Please ask for: Sian Eggington
Email: sian.eggington@terraquest.co.uk
Telephone: 0121 234 1390
Our Ref: BR/293/21/HH
Your Ref:
Date: 13th January 2022

Application for Planning Permission for Works or Extension to a Dwelling

Development: Two storey side and rear extension, rebuilding of existing conservatory and demolition of existing garage.
Location: 73 Nyewood Lane Bognor Regis PO21 2SD

9 Block Plan Proposed
1 : 200

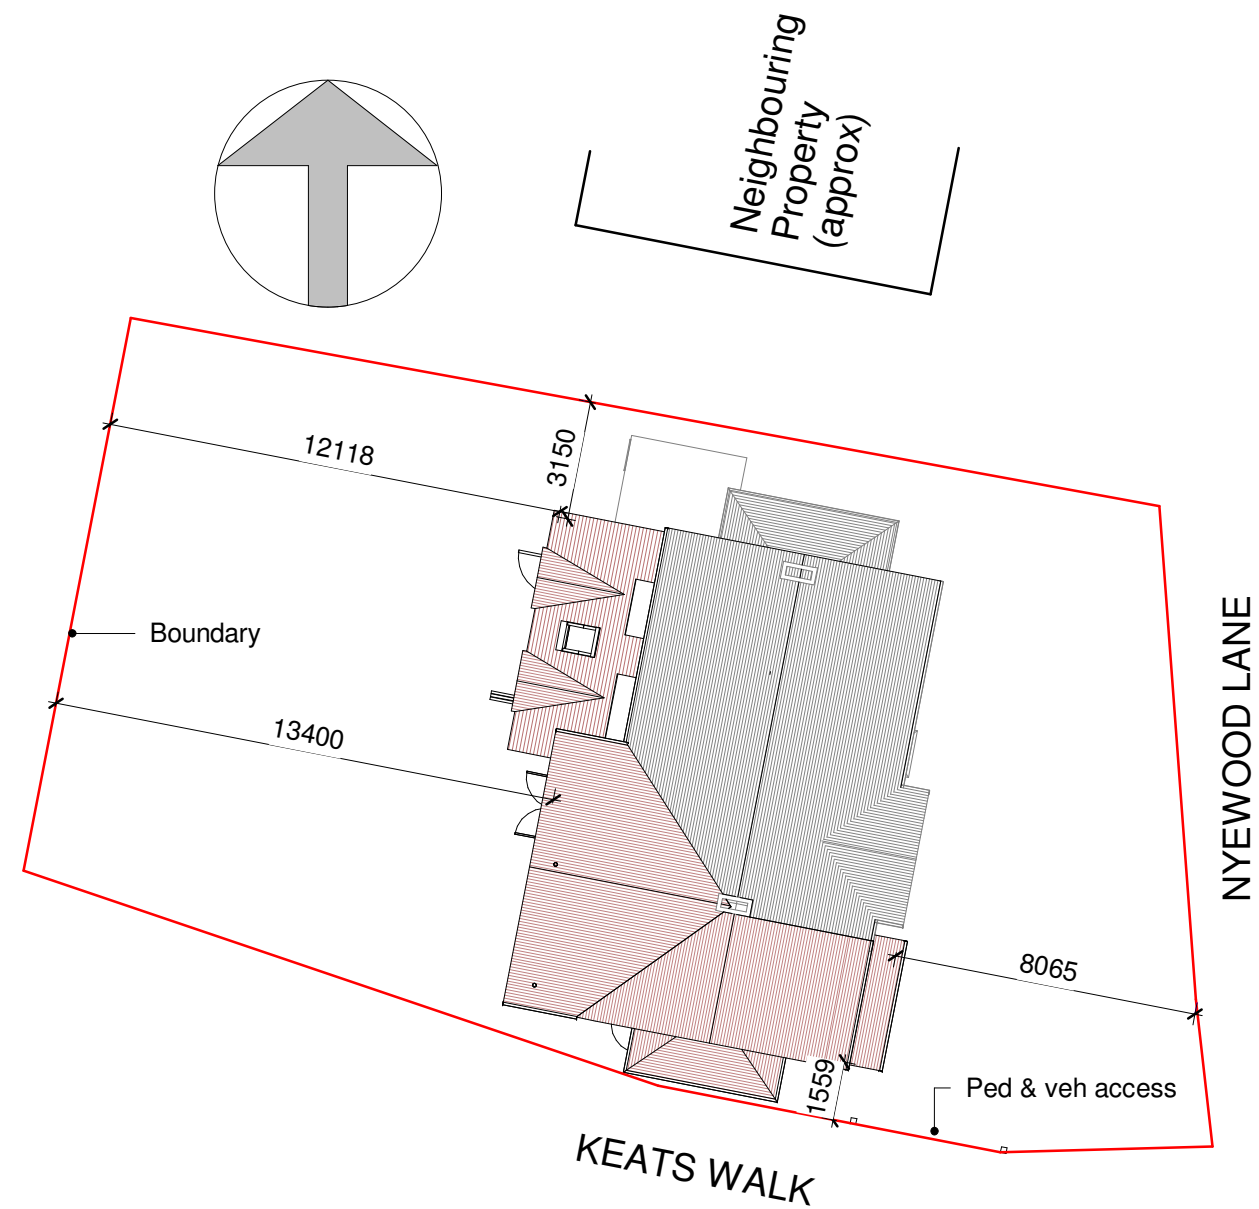
Dimensions: You are required to include dimensions on the block plan from the proposed extensions to all site boundaries.
